WEST SUSSEX COUNTY COUNCIL CONSULTATION

TO:	Arun District Council FAO: Amber Willard
FROM:	WSCC - Highways Authority
DATE:	11 April 2019
LOCATION:	25 Mons Avenue, Bognor Regis, PO21 5JN
SUBJECT:	BR/66/19/HH Two storey side extension and conversion of existing conservatory into pitch roof extension including installation of vehicular crossover to front.
DATE OF SITE VISIT:	N/A
RECOMMENDATION:	Advice
S106 CONTRIBUTION TOTAL:	£N/A

Proposed Ground Floor Plan

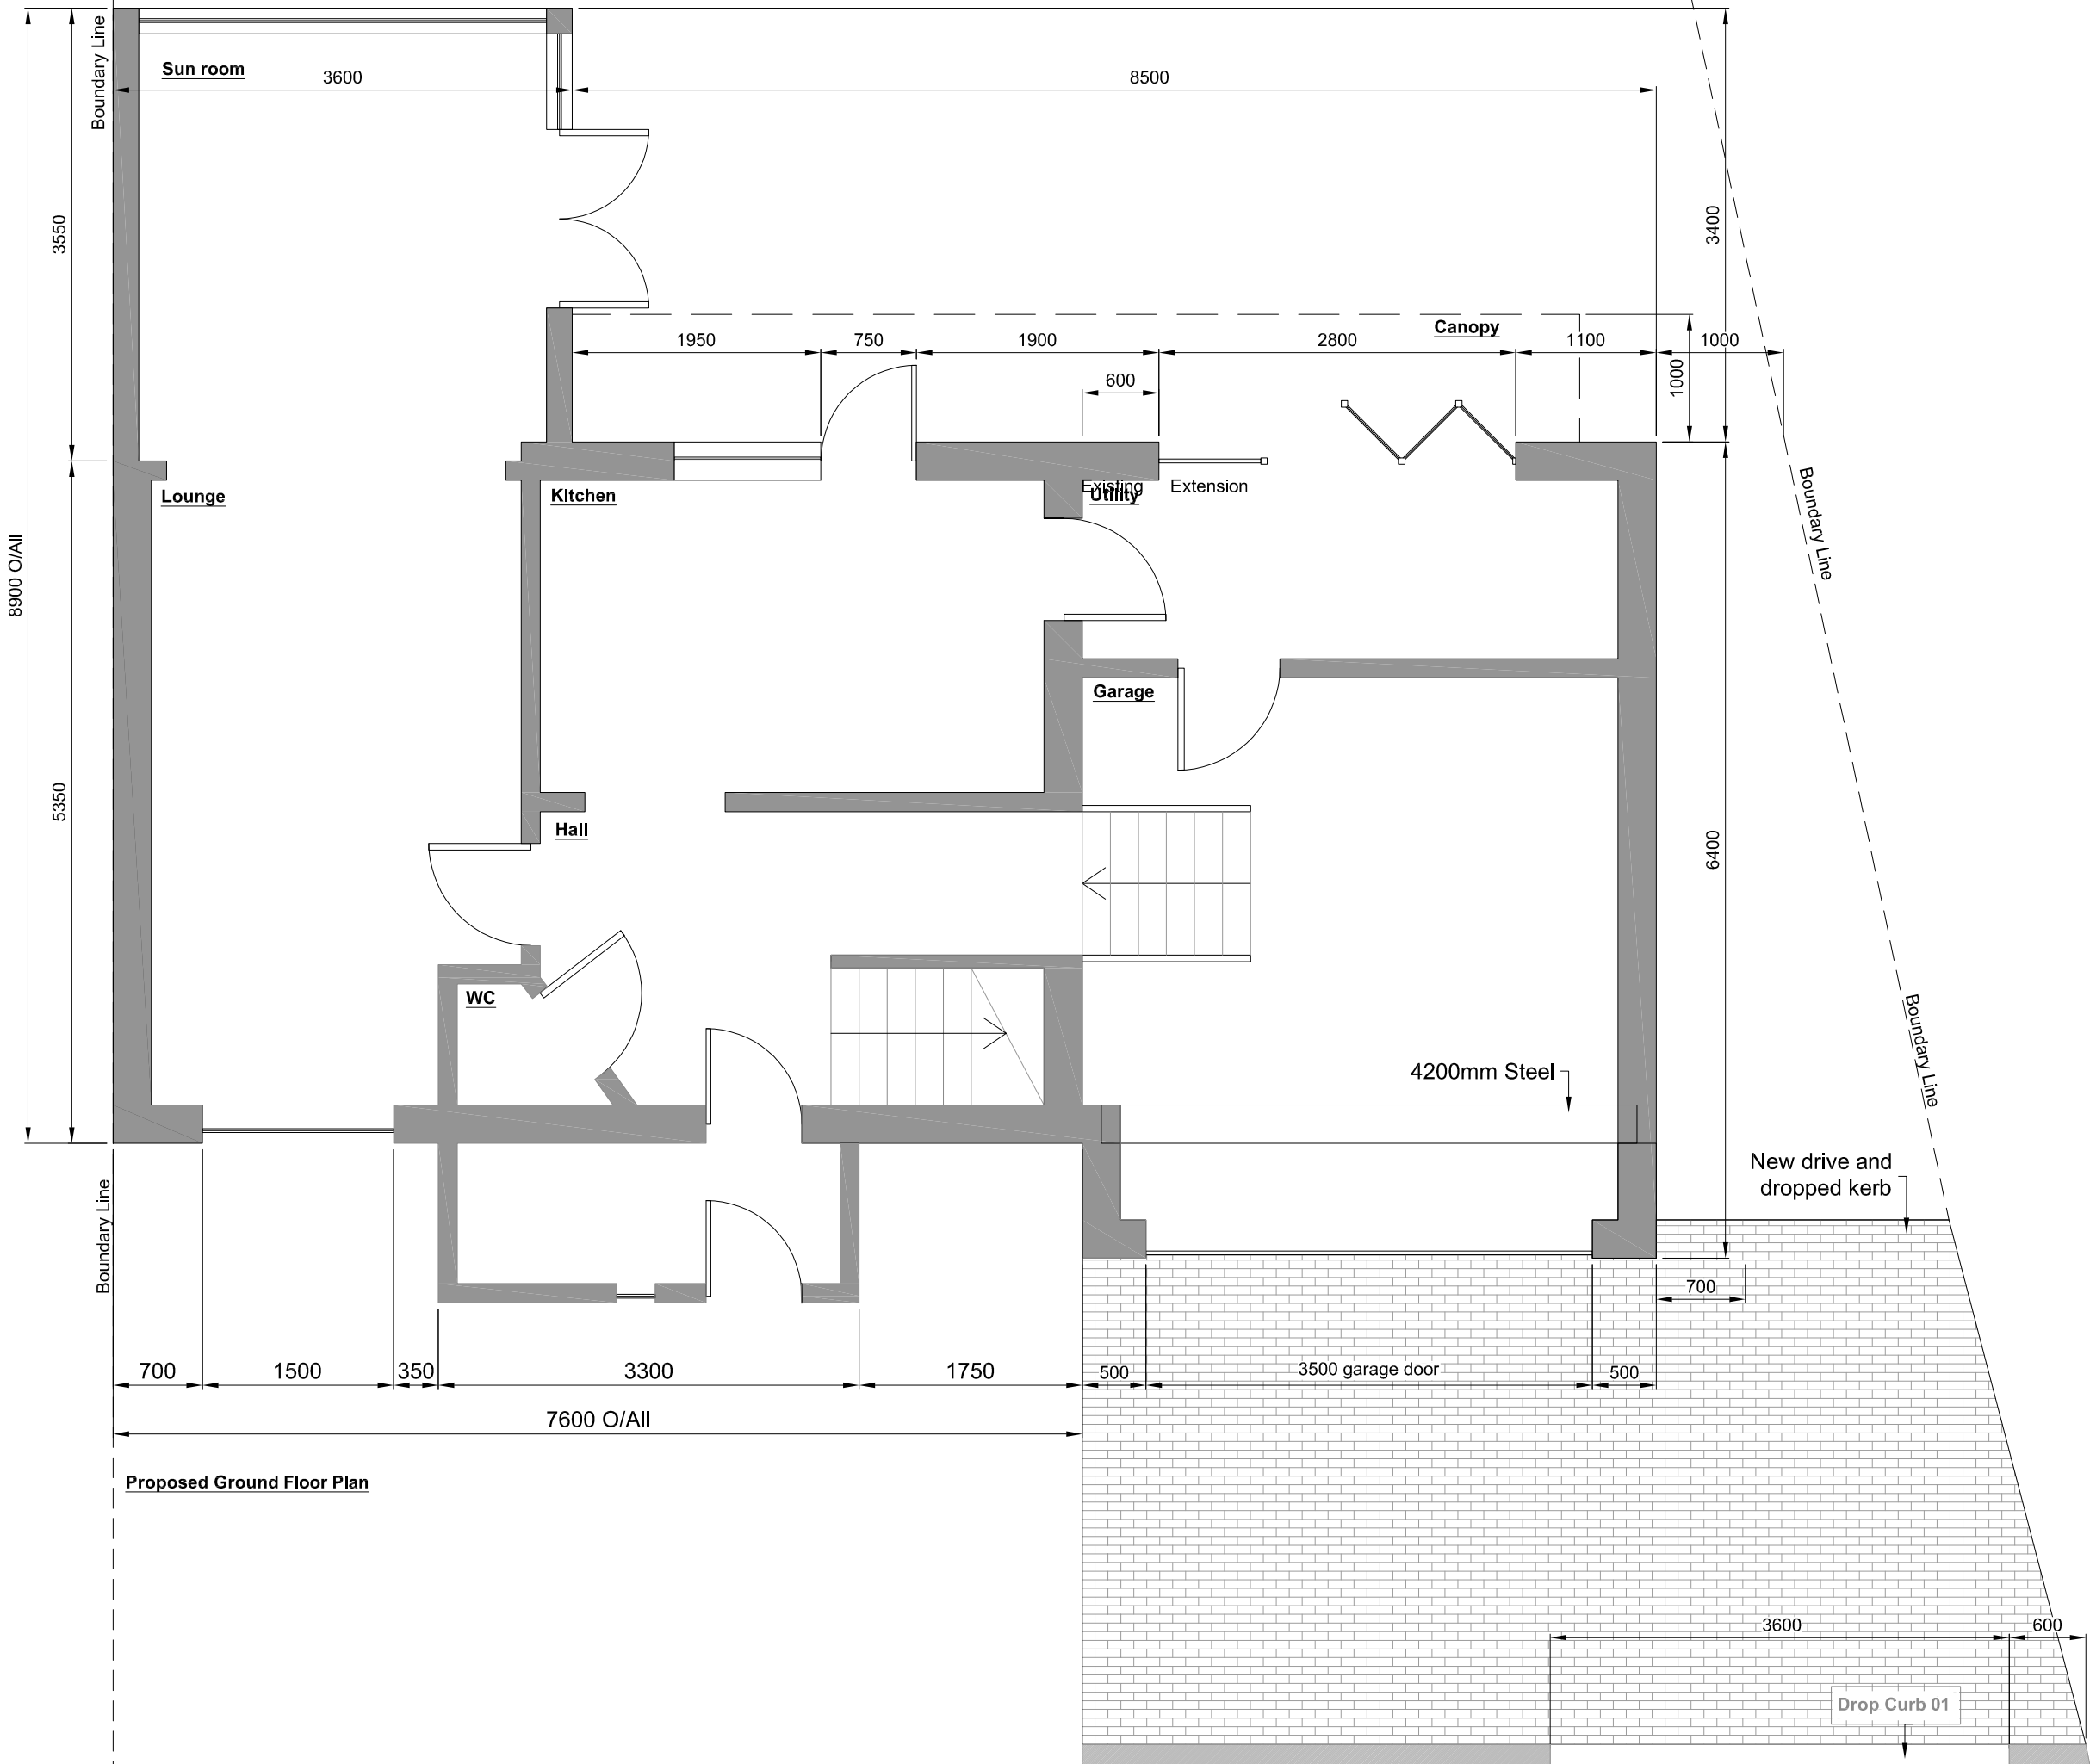
Access to the site will be to the front of the property. Visibility splays were sufficiently demonstrated in the plans. The neighbouring property appears to have a similar access to the one proposed, and collision data provided to WSCC from Sussex Police from the last five years reveal there have been no reported injury accidents in the vicinity relating to road layout. Therefore there is no evidence to suggest the proposed vehicle crossover would exacerbate an existing concern.

The proposed side extension includes the input of a garage. The internal dimensions of the garage will allow for one car to park inside. By using the WSCC Car Parking Demand Calculator, a property of this size in this location would create a demand for 2 cars. Therefore, any overspill parking would have to be accommodated on-street. Considering the proposed development will take 1 parked car off the street, the Local Highway Authority (LHA) considers the proposed development an improvement of the existing parking arrangement.

Turning on-site will not be achievable, so vehicles will have to exit the property in a reverse gear. Given that neighbouring properties have similar arrangements without incident, the LHA does not consider this detrimental to highway safety.
